RE: Responses to Comments – Technical Review 2  
White Barn – Chick-Fil-A  
Highway 9 and Soper Hill Road, Marysville, Washington 98258  
Permit No. PA23-019 / Our Job No. 22579

We have revised the plans and technical documents for the above-referenced project in accordance with your comments dated May 3, 2024. The following outline provides each of your comments in italics exactly as written, along with a narrative response describing how each comment was addressed:

Drawing file: htcomnet / public

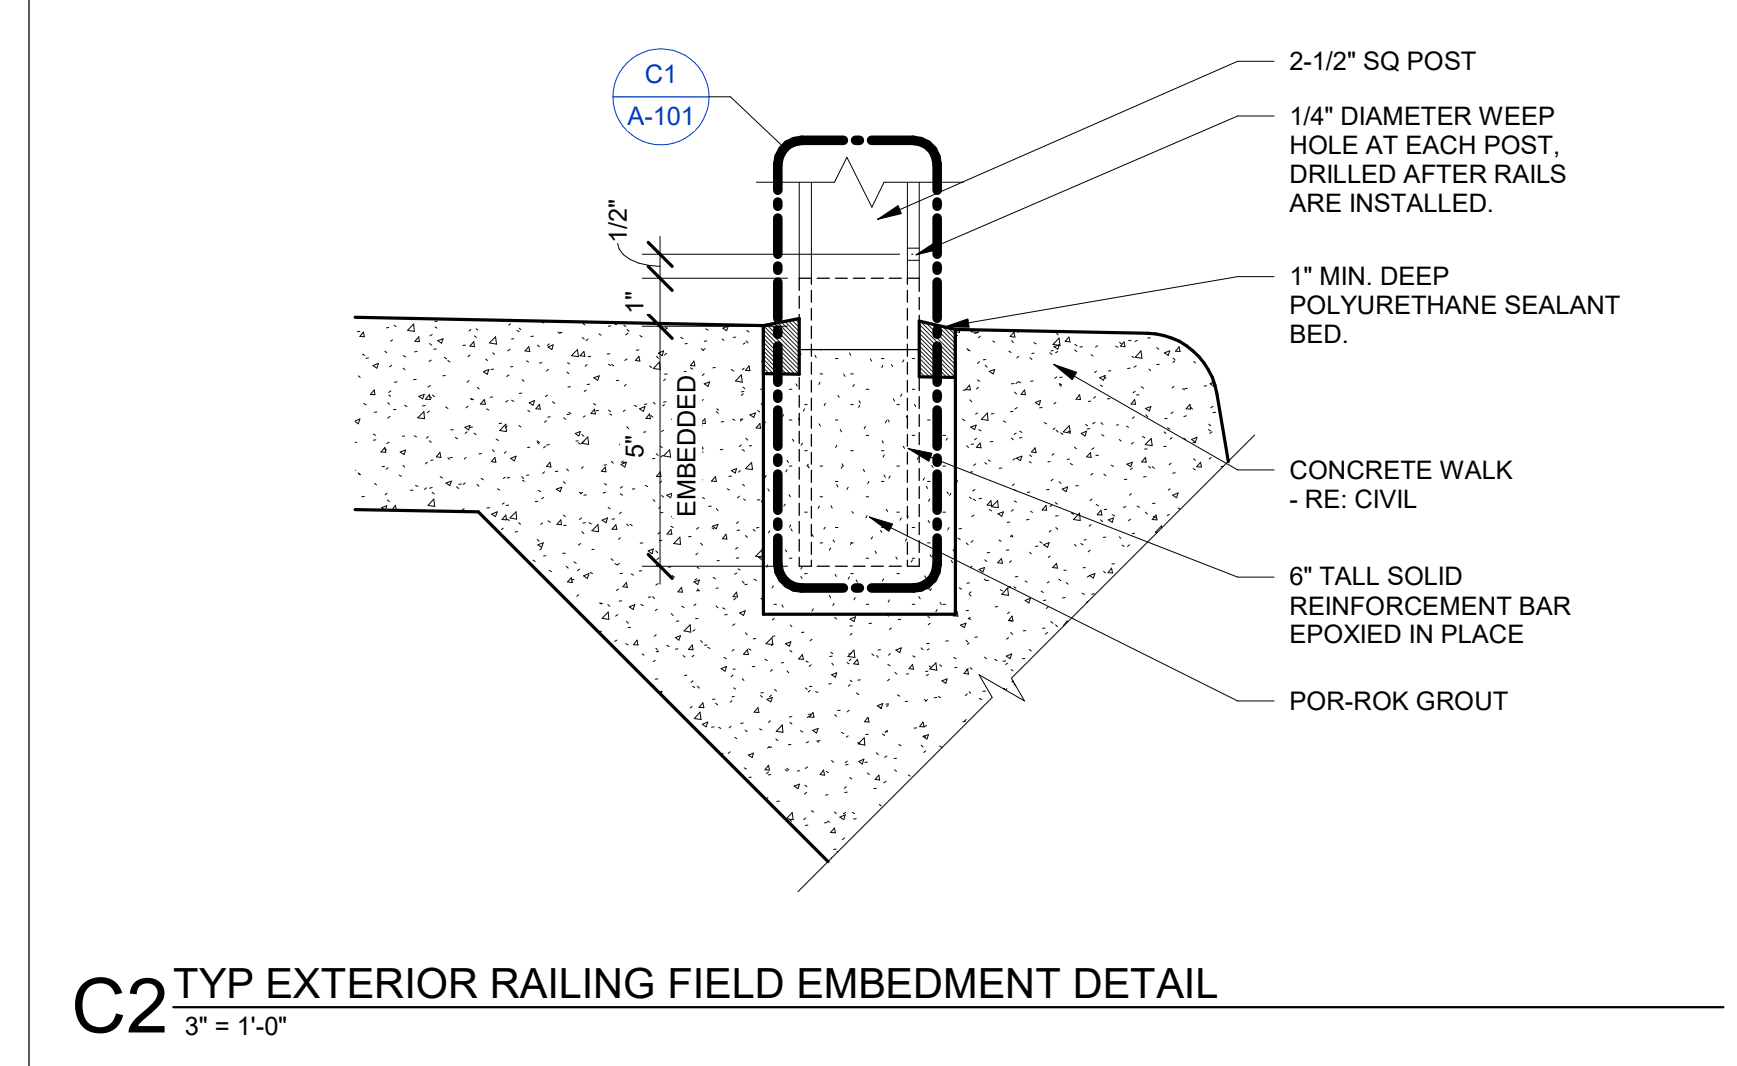
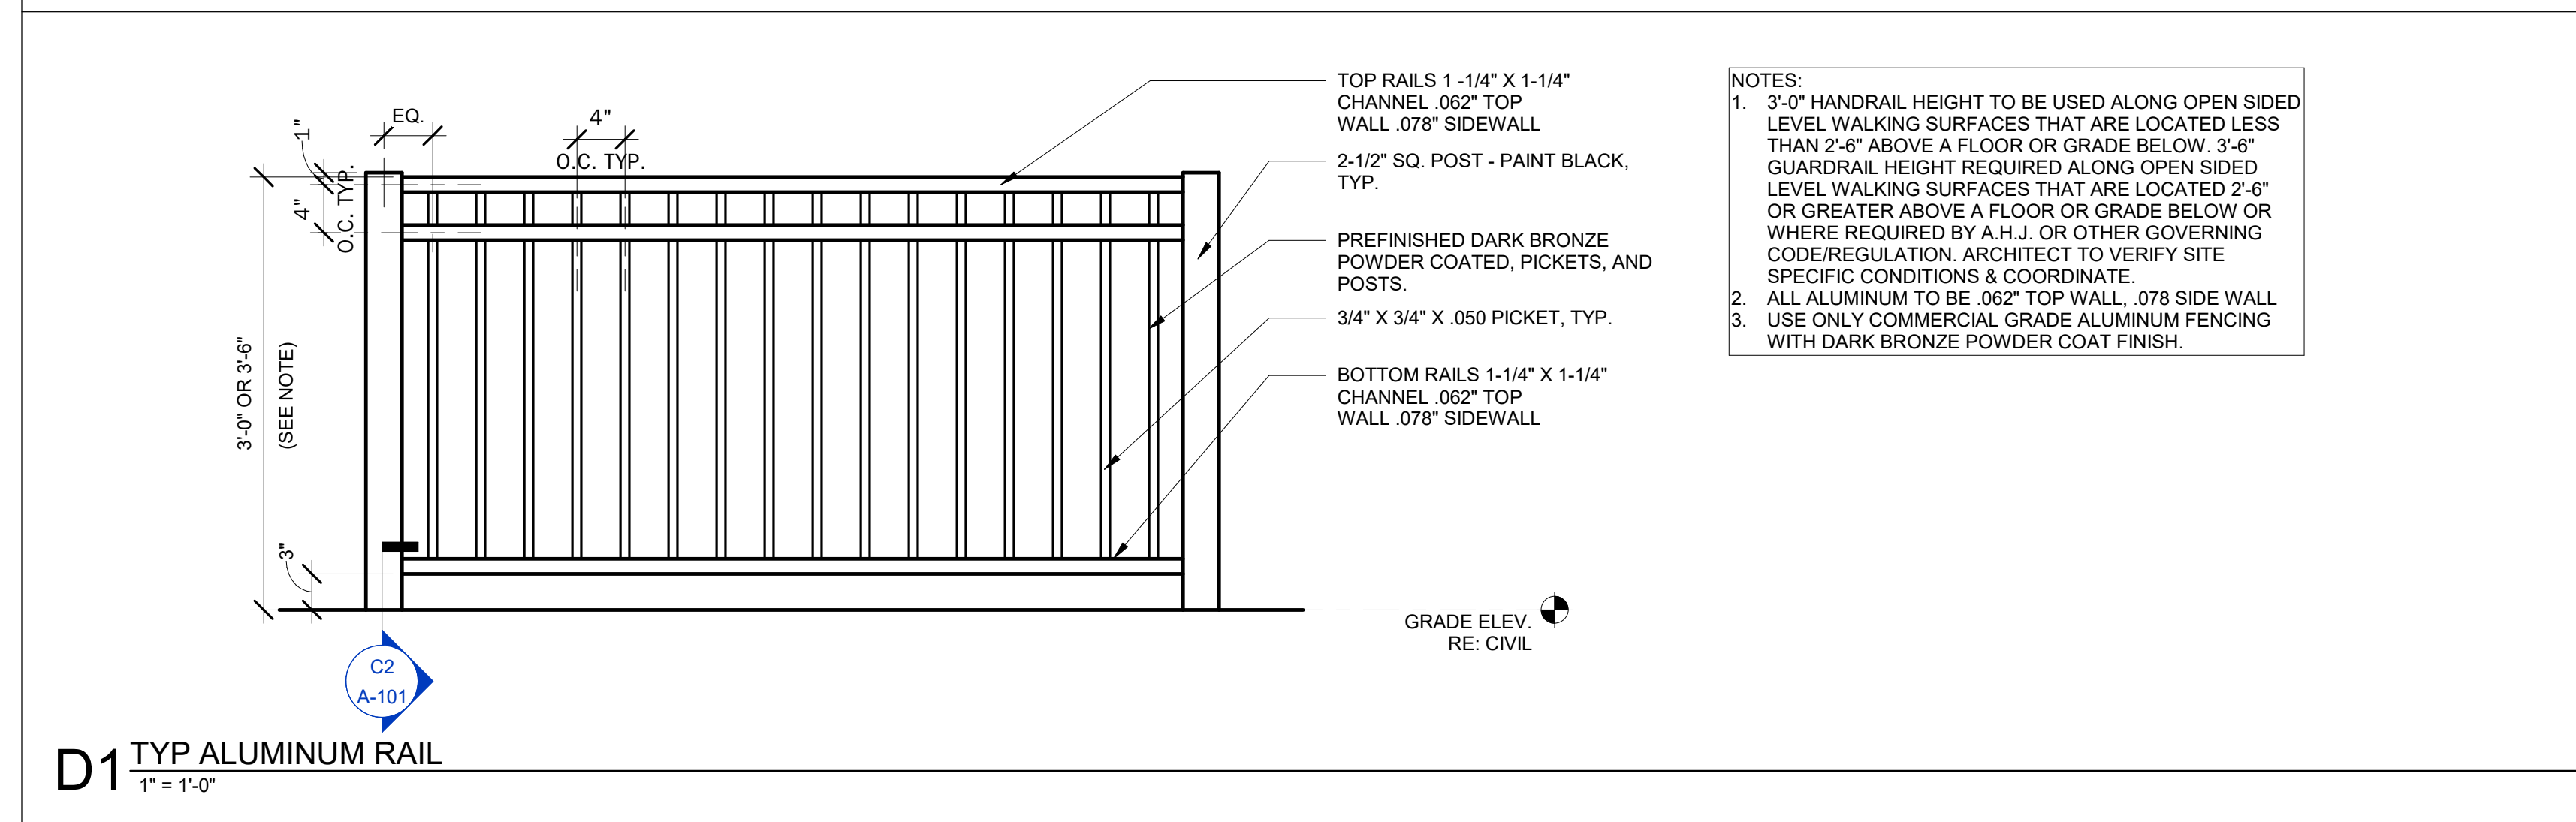
*In discussion with the Director, the City is willing to reduce the landscape buffer along Soper Hill Road and 87th Avenue NE to a 10' L2 buffer, with a decorative screen wall that is constructed with materials that are complimentary of the proposed restaurant. Colored architectural drawings and a revised screen wall will need to be submitted for Director approval. At this time it is unclear if the two examples provided would meet this criteria. The Renton, WA example would not be acceptable.*

Sheet A-101 is provided with this submittal for the proposed screen wall design semi-opaque from the ground to a height of 3 feet with visual obstruction above the opaque portion using decorative metal screening.

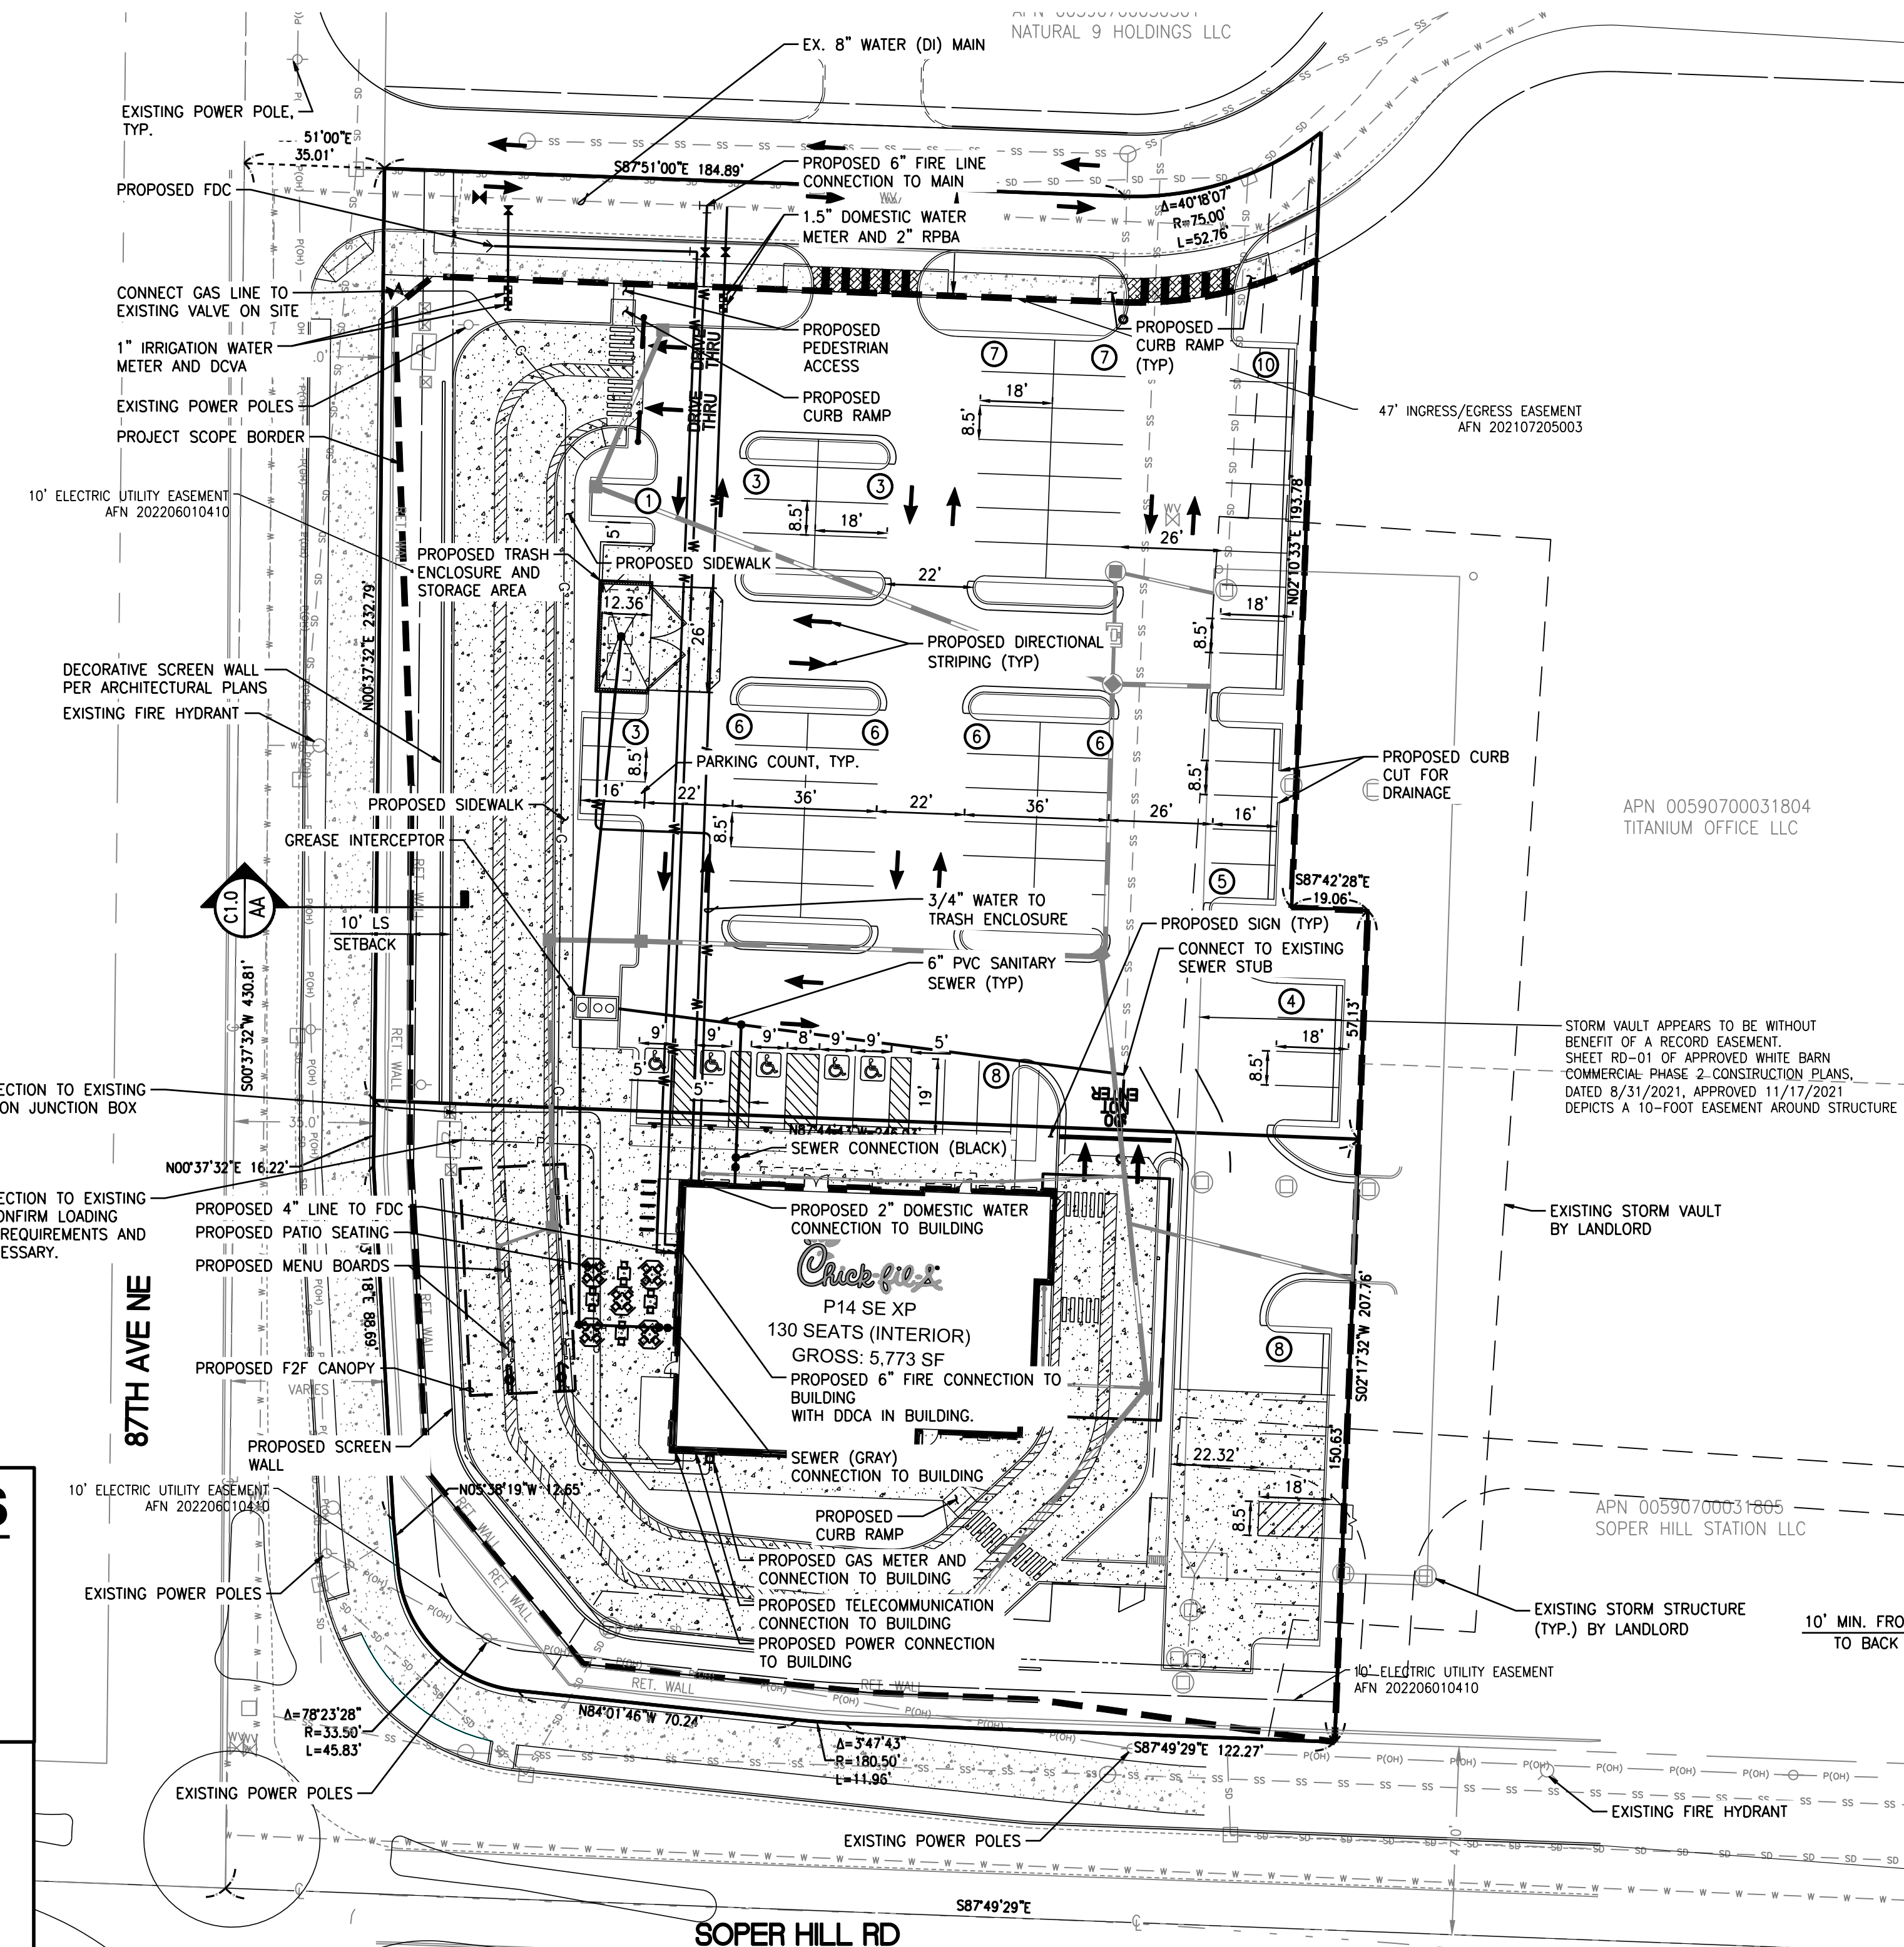
4. *Provide required open space calculations and identify the location of the required open space on the site plan. Non-residential uses shall provide pedestrian-oriented space, defined in subsection (2)(c) (see design standards for qualifications), at a rate of 2% of the site, plus 1% of the building floor area. Required sidewalks and walkways shall not count as pedestrian-oriented space. See MMC 22C.070.100(2)(c) for examples of qualifying pedestrian oriented open space.*

**Response:** This information has been provided on Sheet C1.0 on the bottom left hand of the sheet demonstrating that the project is in compliance with this requirement.
